KITTITAS COUNTY

MEMORANDUM

TO: All Staff
FROM: Public Works Plan Review Team
DATE: January 27, 2023
SUBJECT: BL-22-00025 Ritchie

RITCHIE PROPERTY

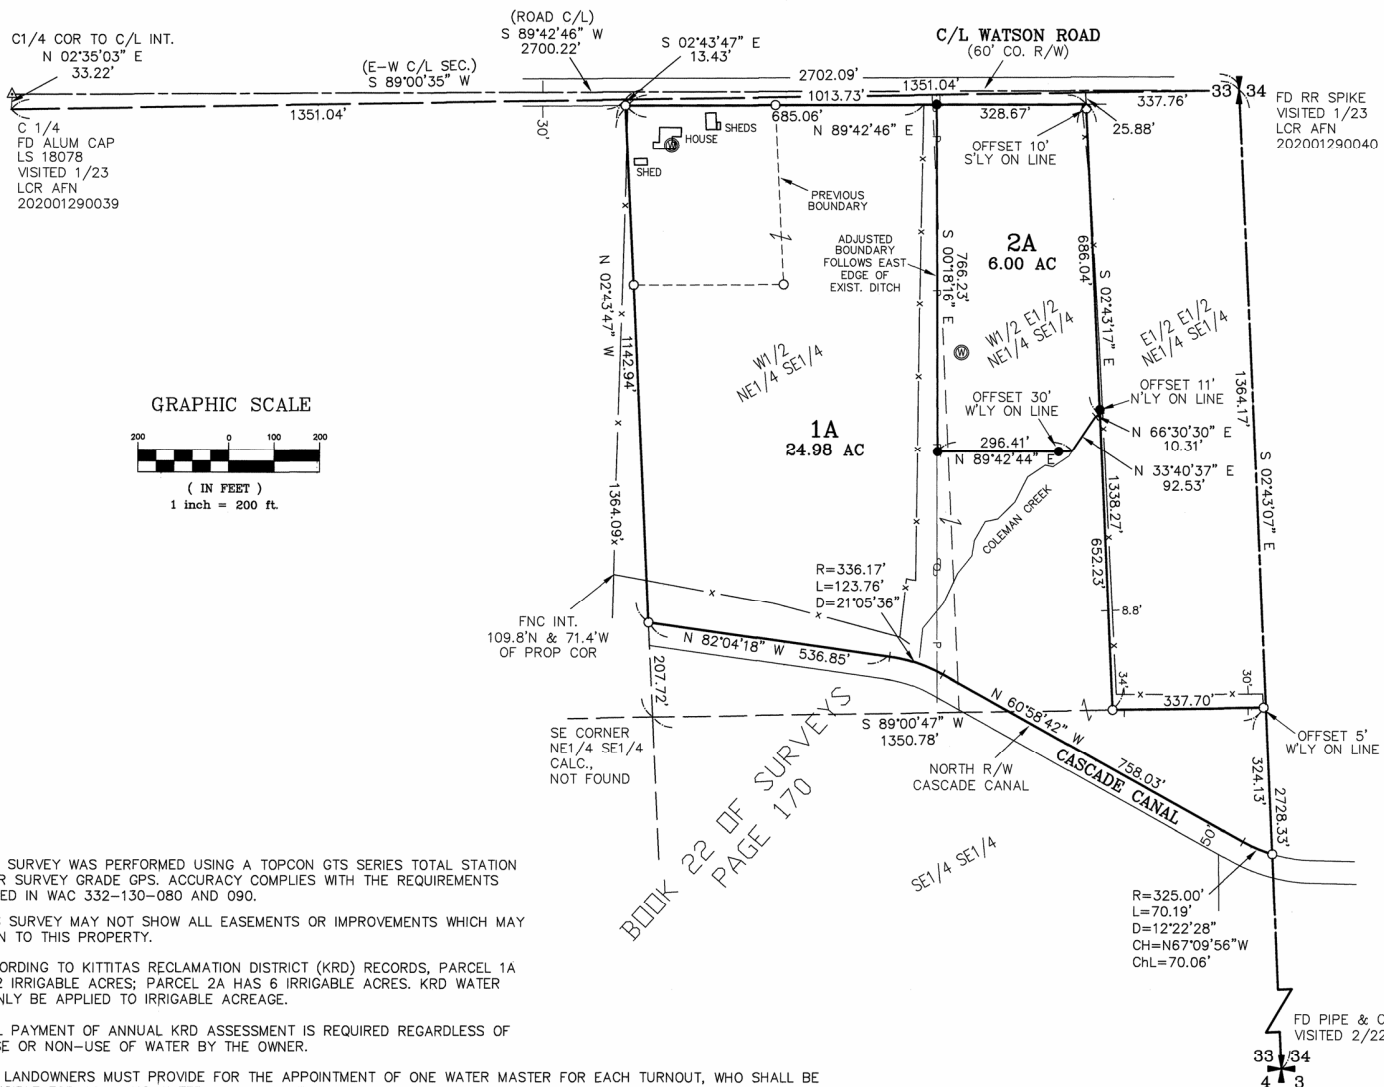
<p>ENGINEERING</p>	<p>No Comments</p>
<p>SURVEY</p>	<p>One of the southernmost corners of Lot 2A is labeled with an easterly offset. It appears that the label should be a westerly offset.</p>
